Gateway Trucking Transportation Memorandum (LSC #S214360) May 20, 2021

¹ Update to
Transportation
Memorandum and
Road Conditions
Report.

LSC Responses to EPC PCD TIS Redline Comments

Figure 3

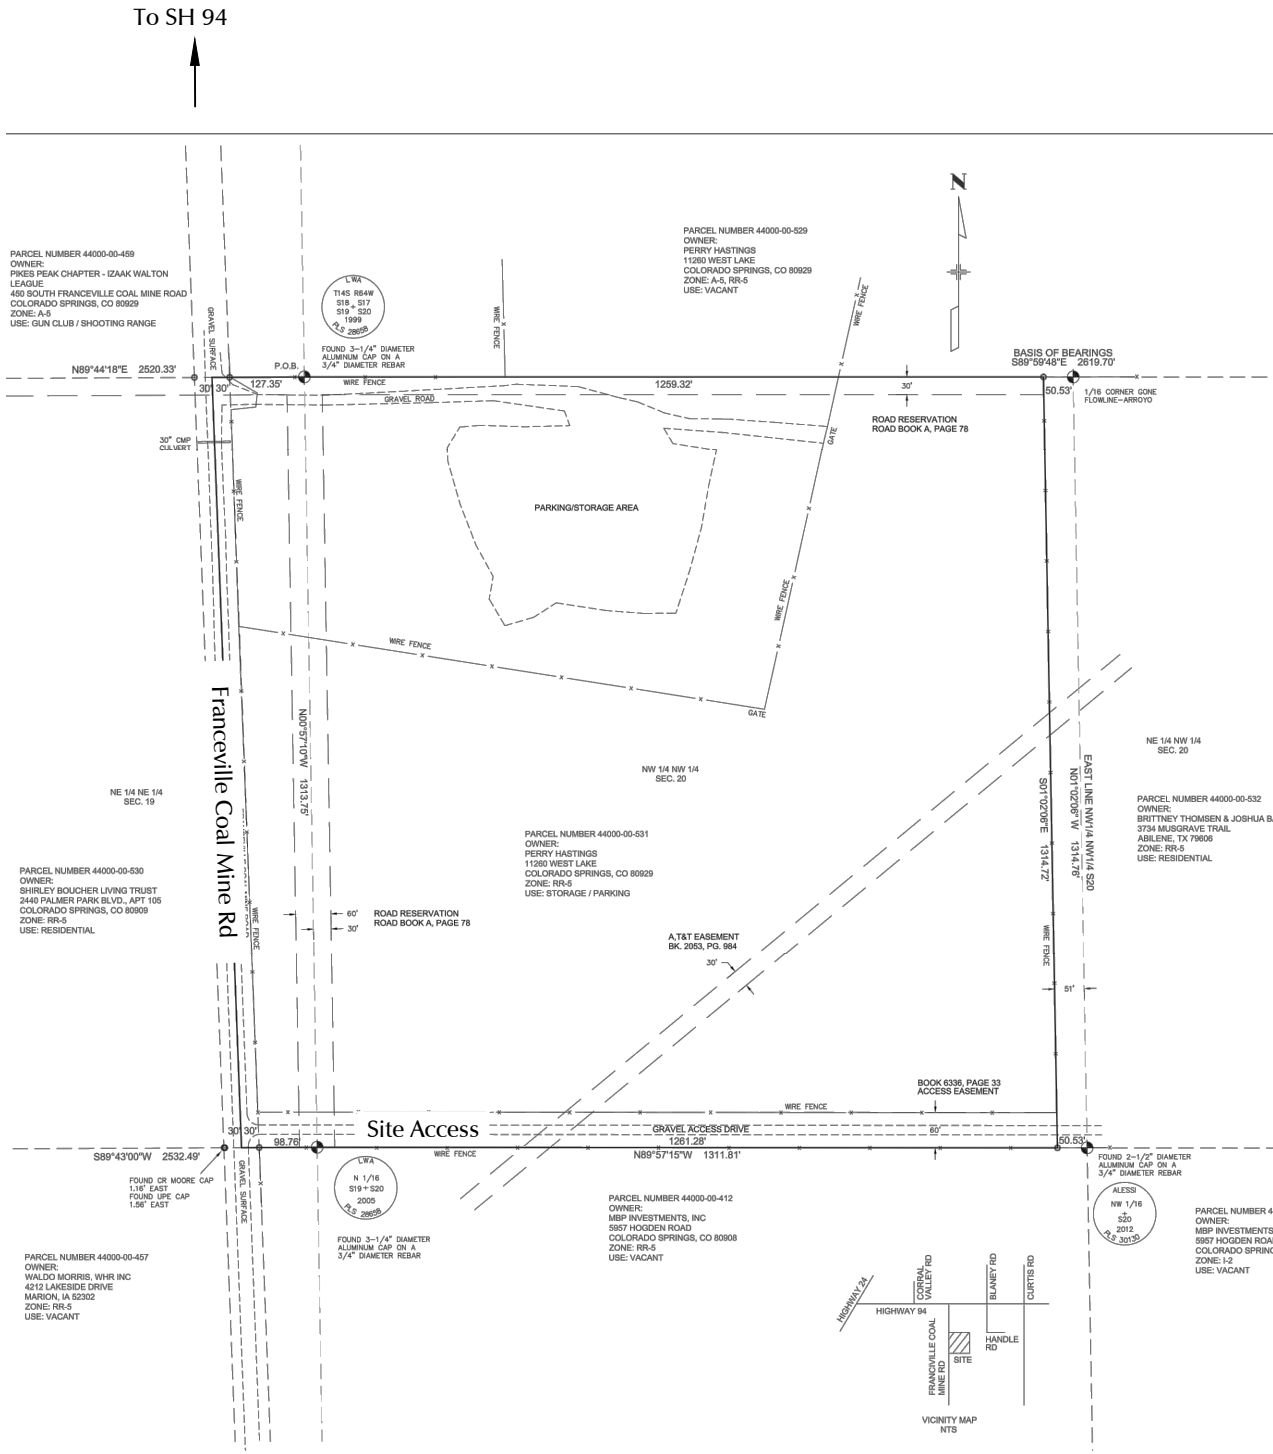
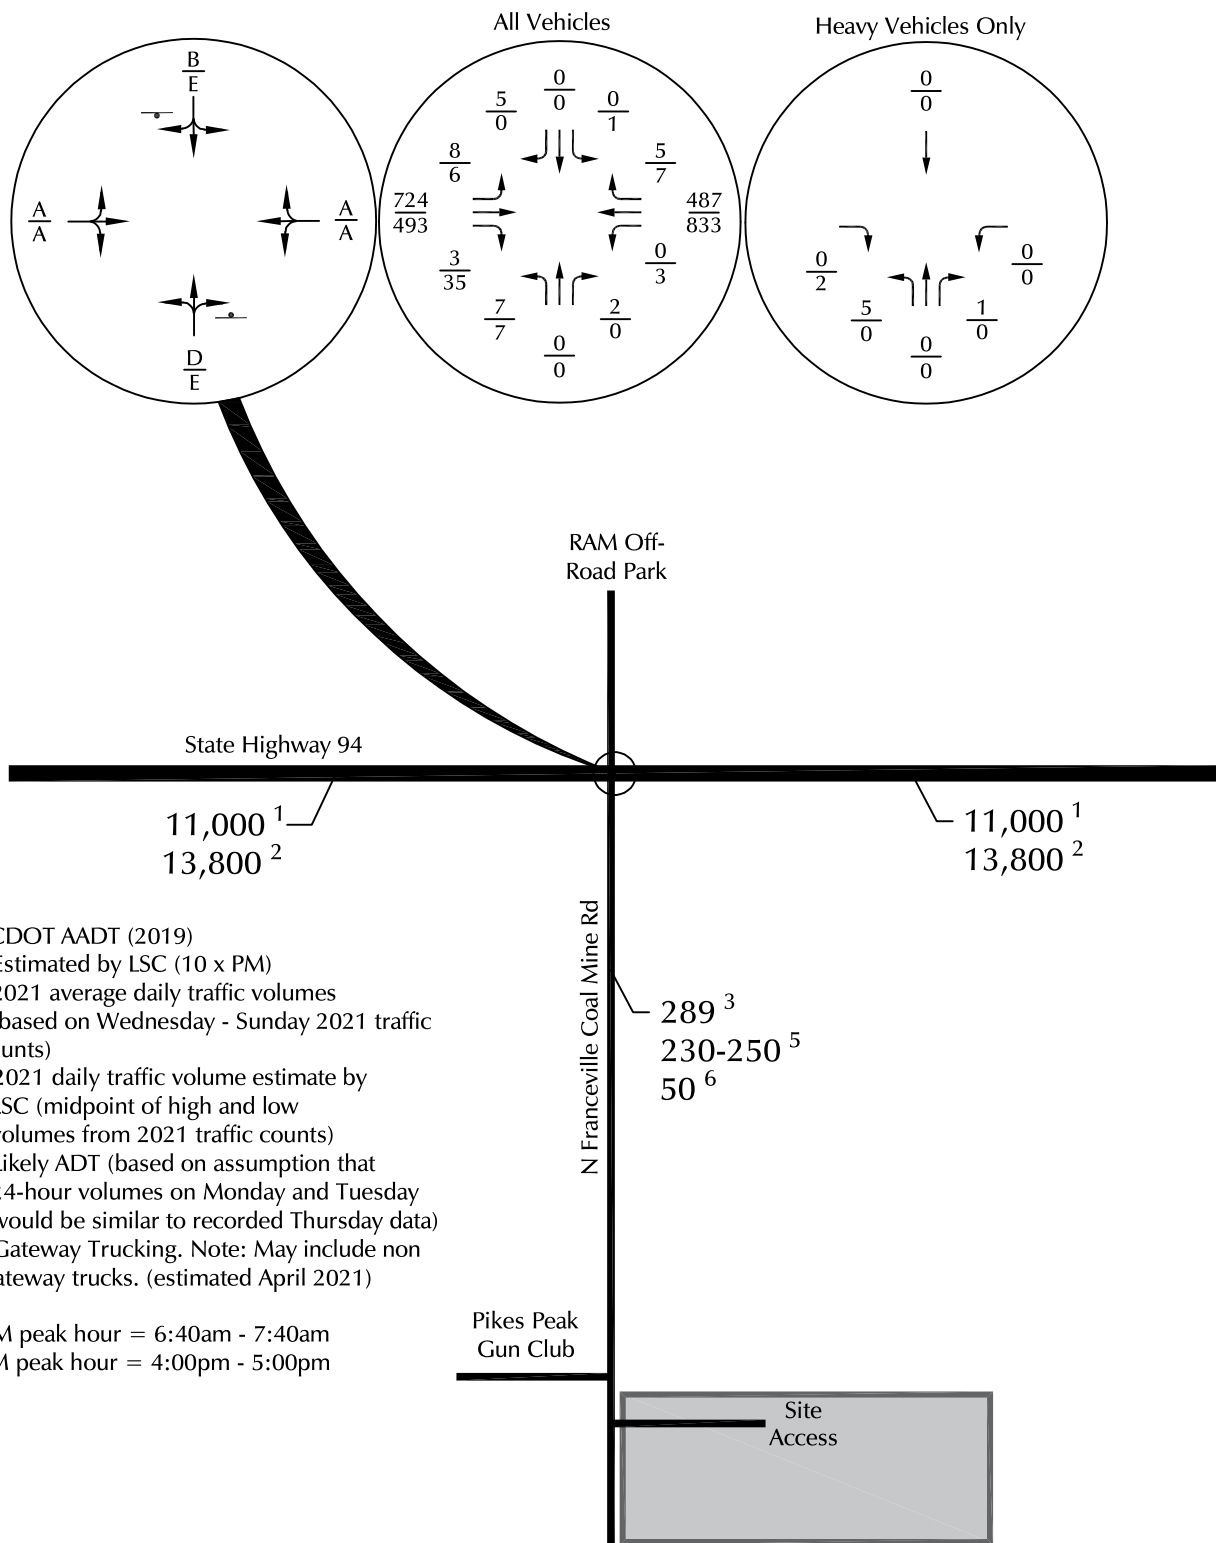
[Update the exhibit to include the traffic volume with superscript 4.](#)

LSC Response:
Updated as requested.
